From: Kathryn Welch
Sent: 28 April 2021 09:05

Subject: FG/52/21/HH 19 Highdown Way

Proposed Front Elevation
Scale: 1:100

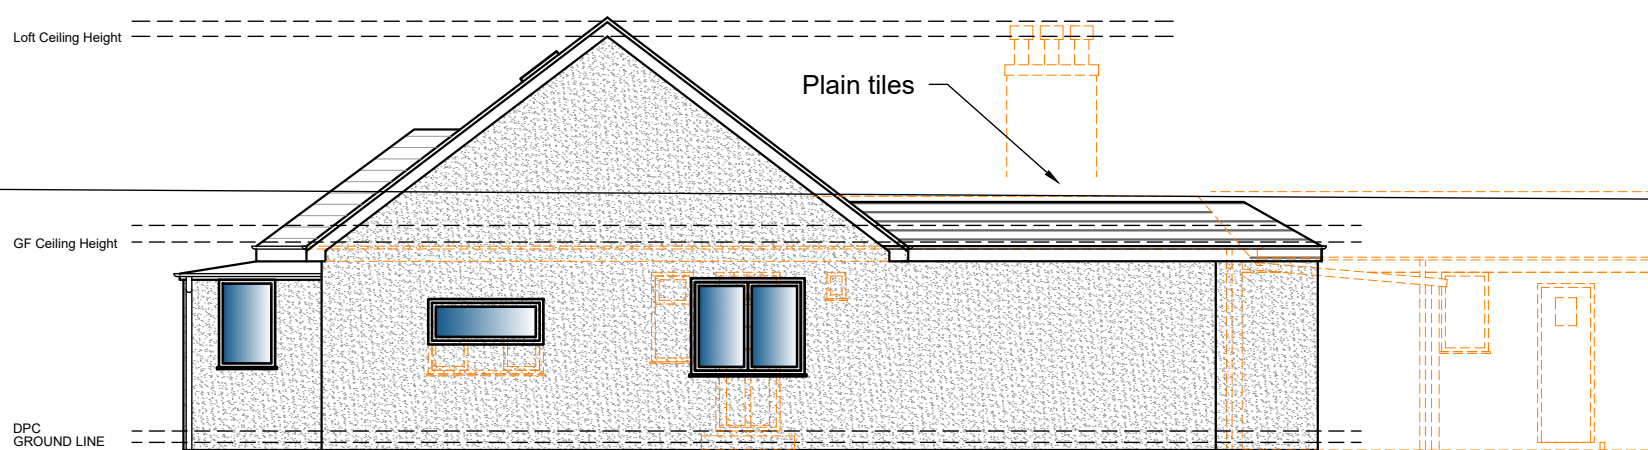
In looking at the plans I believe there to be slight error on the proposed plans, specifically the front elevation. It looks as if the side portion of the extension has a flat roof? Also I believe there is a small remnant of the existing roof line showing on the RHS of this elevation behind the main roof line. Additionally, the block plan shows a gap between the boundary and the edge of the extension of 960mm however the floor plan show the extension hard up against the fence line, is the fence line not on the same line as the boundary? If you could check these issues for me and amend as applicable I would be grateful.

Could I also confirm with you why you have chosen to raise the eaves level of the extension; it appears to be an unusual technique when in theory the roof line could merge with the existing roof plane?
